PERMIT # 6755 CITY OF Portland BUILDING PERMIT APPLICATION

RE: 11 Humboldt Street

Your application to move single family dwelling from Windham, Maine has been reviewed and a permit is herewith issued subject to the following requirements:

This is in reference to your site plan submitted for 11 Humboldt Street in the R-3 Residence Zone in Portland. The site plan as prepared for this proposed single family dwelling has been disapproved by the Public Works Department due to the following reasons:

SITE PLAN
ON
HUMBOLDT STREET
PORTLAND, MAINE
FOR
S & T ENTERPRISES
JULY 19, 1989 JOB 89034 SCALE 1" = 40'
PREPARED BY:
THE LAND SURVEY TEAM
A DIVISION OF MONMOUTH, LTD.
SACO, MAINE

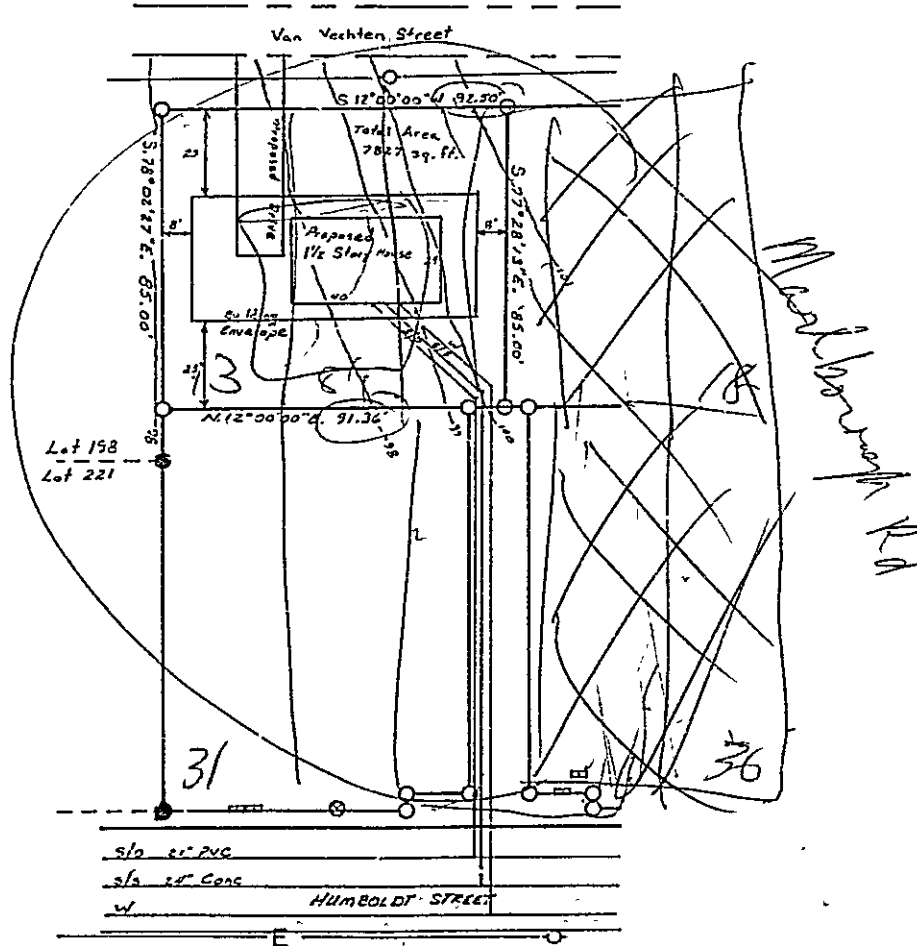
"Access to property not from an improved City street;"
VanVechten Street is the unaccepted street which the proposed dwelling faces and on which the proposed driveway is to be located for access.

"Drainage not adequate as demonstrated."

Inspection Services Approved W. Giroux
Public Works Access to property (House) must be from Humboldt Street as defined in City of Portland Code Section 14-403B. Paved drive with tip downs on either side of curb cut.
